Response to Planning Application

Application ref: AL/29/20/PL

Description: Demolition of existing house & outbuildings & erection of 1 No. dwelling & detached garage. This application is CIL Liable.

Location: Tyrone House Norton Lane Norton Aldingbourne PO20 3NH

-  Widened entrance to site
-  Proposed new dwelling
-  Proposed new outbuilding (garage)
-  As permitted AL/105/19/HH

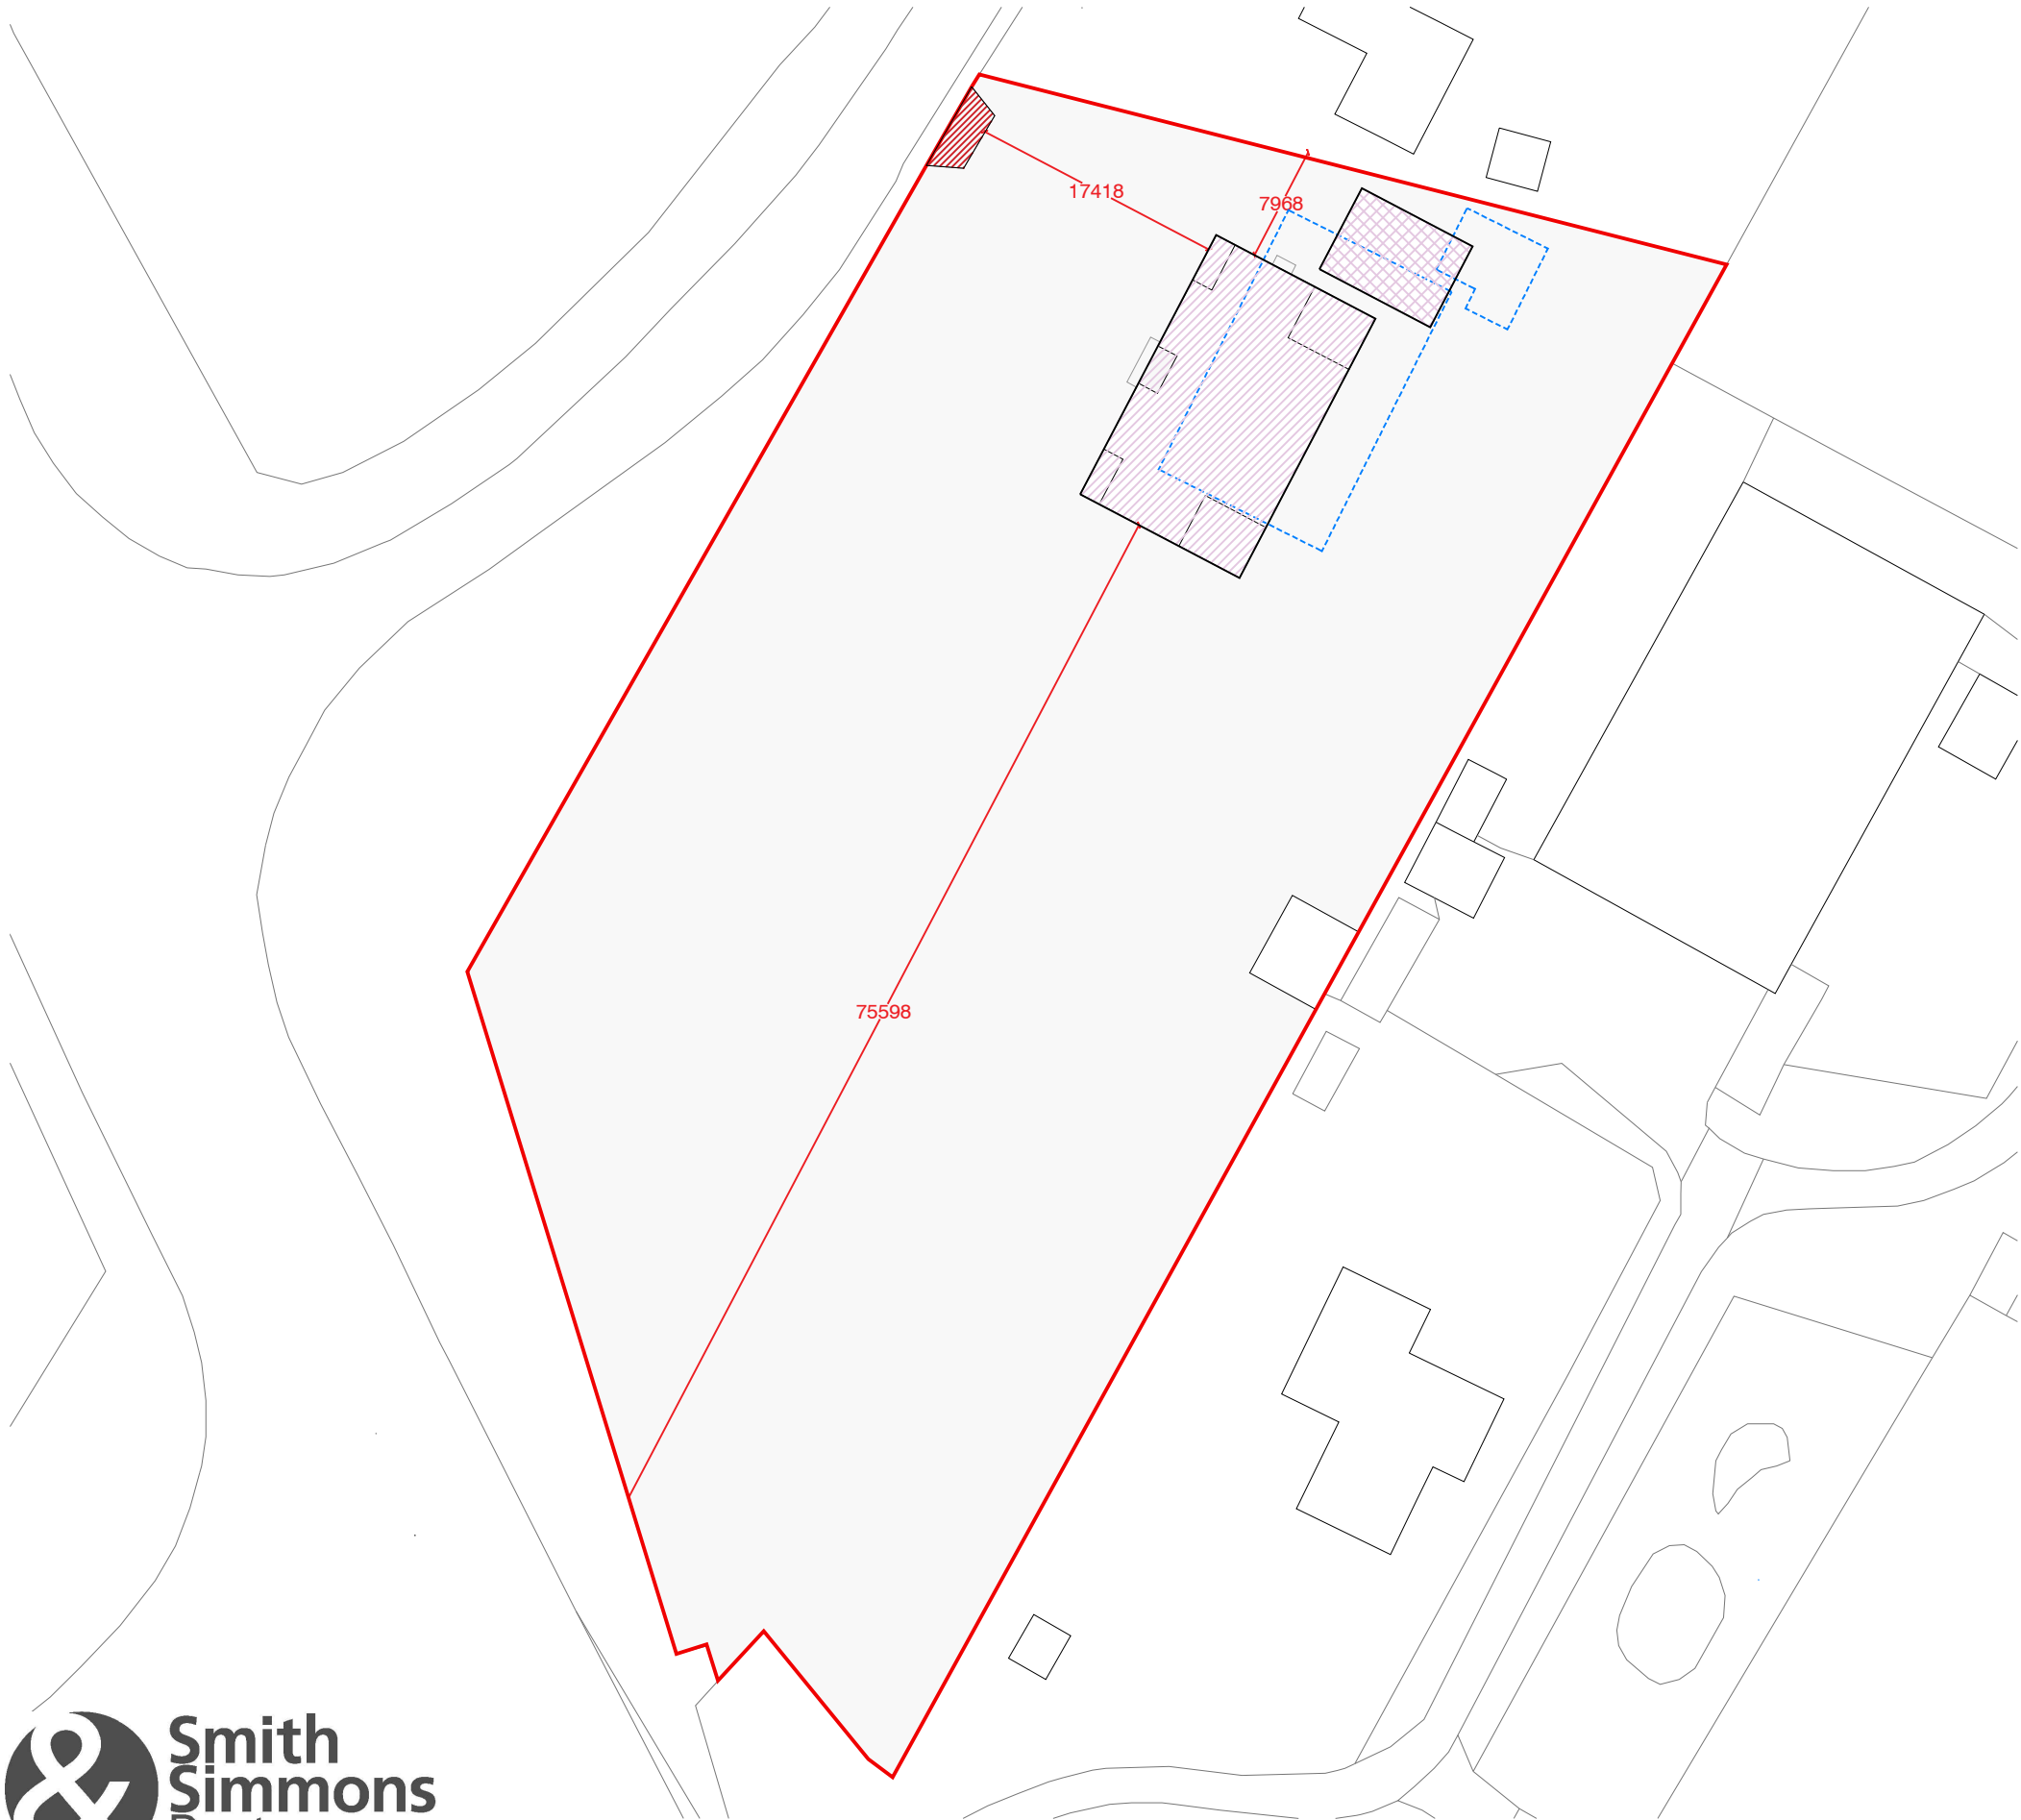
The NPPF para 124/127 relate to good design principles. The indicative location plan has suggested the retention of the majority of the existing trees and inclusion of new landscaping to this development would be required to be submitted and approved. The inclusion on new landscaping for these proposals should be in consideration of greening and screening and should also consider the biodiversity net gain to be achieved with this development.

The potential impact of the proposals could be blended into the surrounding environment with further thought given to the landscape offer and greening to counteract this. Tree protection would need to be a consideration of these proposals both for on and offsite adjacent trees.

No landscape detail has been shown for this development at present. A landscape scheme in plan form would be required to show retained trees and shrubs with proposed plant species detailed along with planting quantities, densities and size at time of planting. All areas should be considered and their connection for biodiversity and habitat explored. All planting specified should be at a suitable size which allow instant impact, but which will establish and mature as the site develops.

I would recommend **no landscape objection** subject to the submission of a detailed landscape scheme to be submitted for approval. Landscape detail to be submitted in plan form to show existing to be retained and new planting detailing species choice, actual quantities, planting densities and size at time of planting.
